Planning Application Ref: AW/354/20/T

Location: 4 The Spinney, Aldwick, PO21 3RL

Description of works: To reduce 3no. maple trees (T2) lateral branches to 6.5m, which are overhanging garage by 1.5 metres. To reduce 1no. oak Tree (T1) lateral branches to 7m spread

1) Oak tree

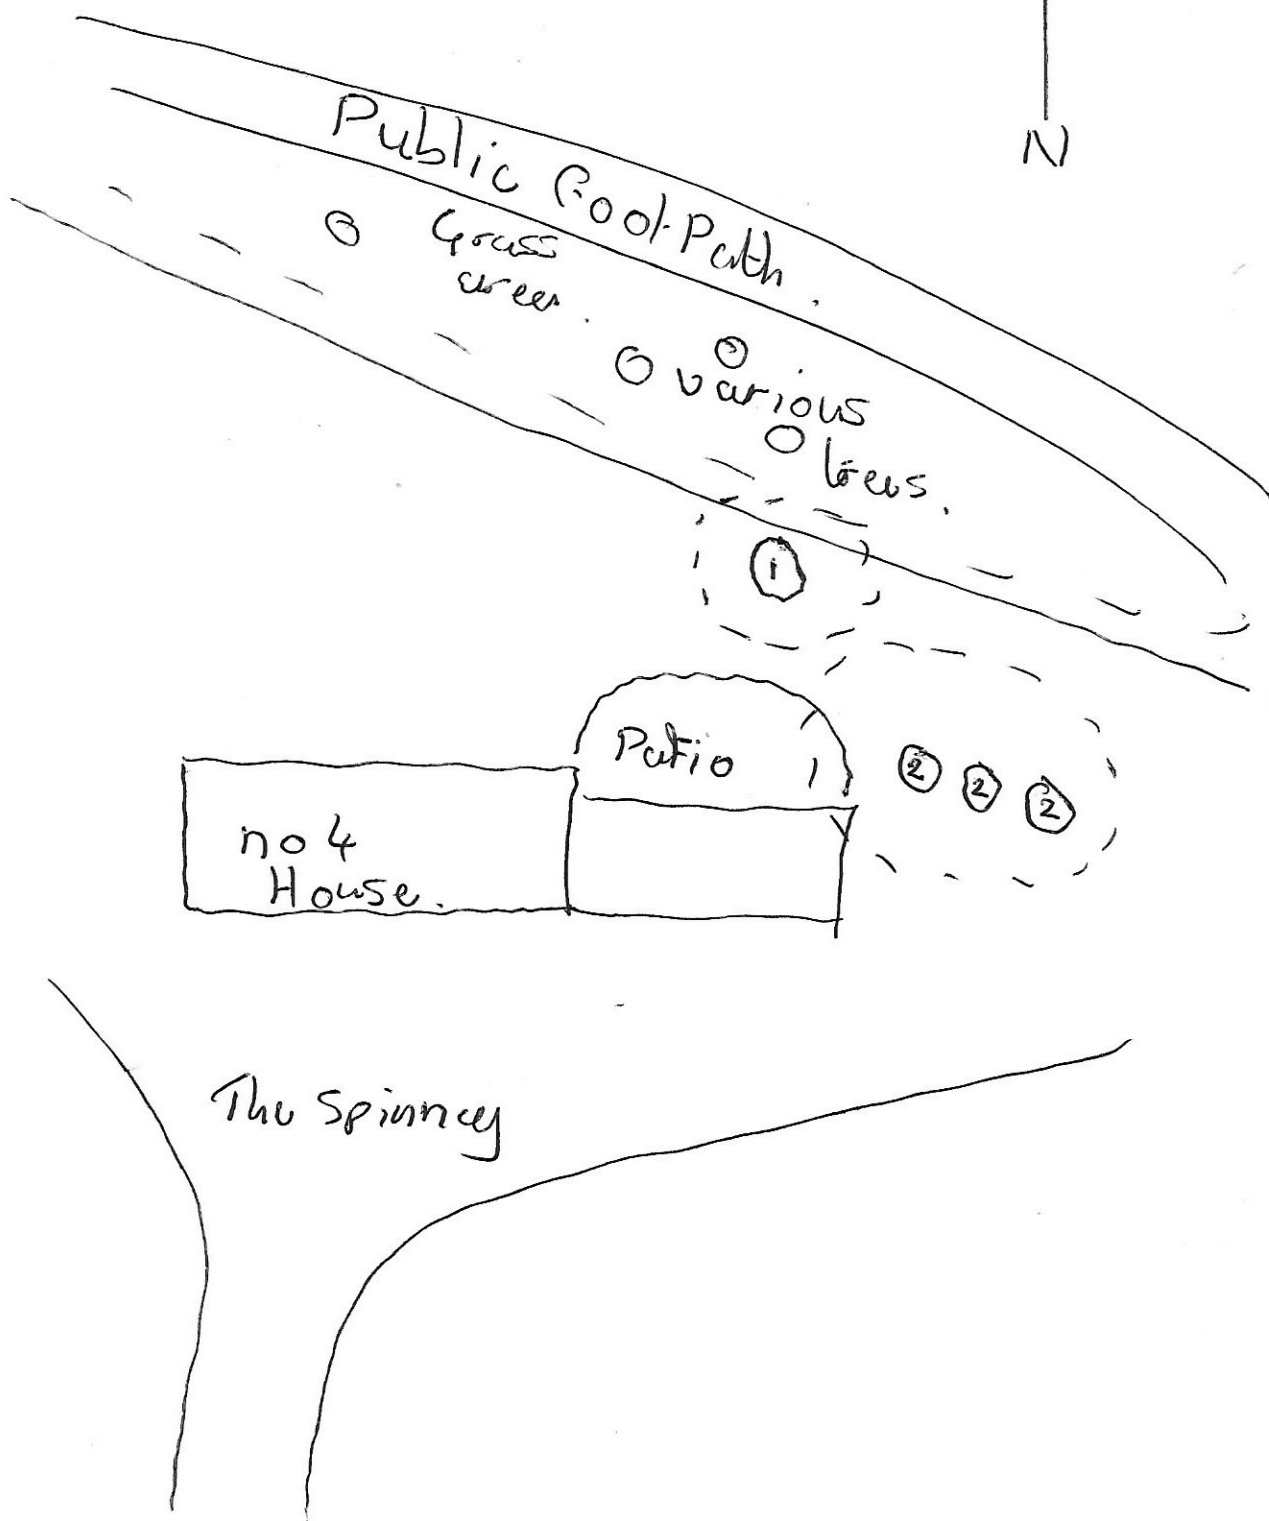
T1 Pedunculate oak / <i>Quercus robur</i>	Height: 10-15m	Radial spread: 5-10m	Age class: Early mature
--	----------------	----------------------	-------------------------

- T1 has slight asymmetric form and with evidence of past pruning to accommodate buildings. Negligible crown extension over patio and with lateral spread towards house/garage approximately 7metres; pruning to the extent described will be minimal and should not have any detrimental effect on the tree.

Part a) Where whole branches are to be removed and final cuts made close to the trunk or branch union they are to be made as shown in Figure 2 of BS3998:2010

Part b) Where branches are to be shortened back the final cuts are to be made at the correct angle shown in BS3998:2010 and adjacent to a live bud or lateral.

T2 3x Field maple / <i>Acer campestre</i>	Height: 5-10m	Radial spread: 0-5m	Age class: Early mature
--	---------------	---------------------	-------------------------

- T2 as 3 of 4 maple in a tight group. Shared crown profile with evidence of past pruning to accommodate buildings. Minor pruning of one aspect to achieve long-term clearance so ought not to have any detrimental effect on the trees.
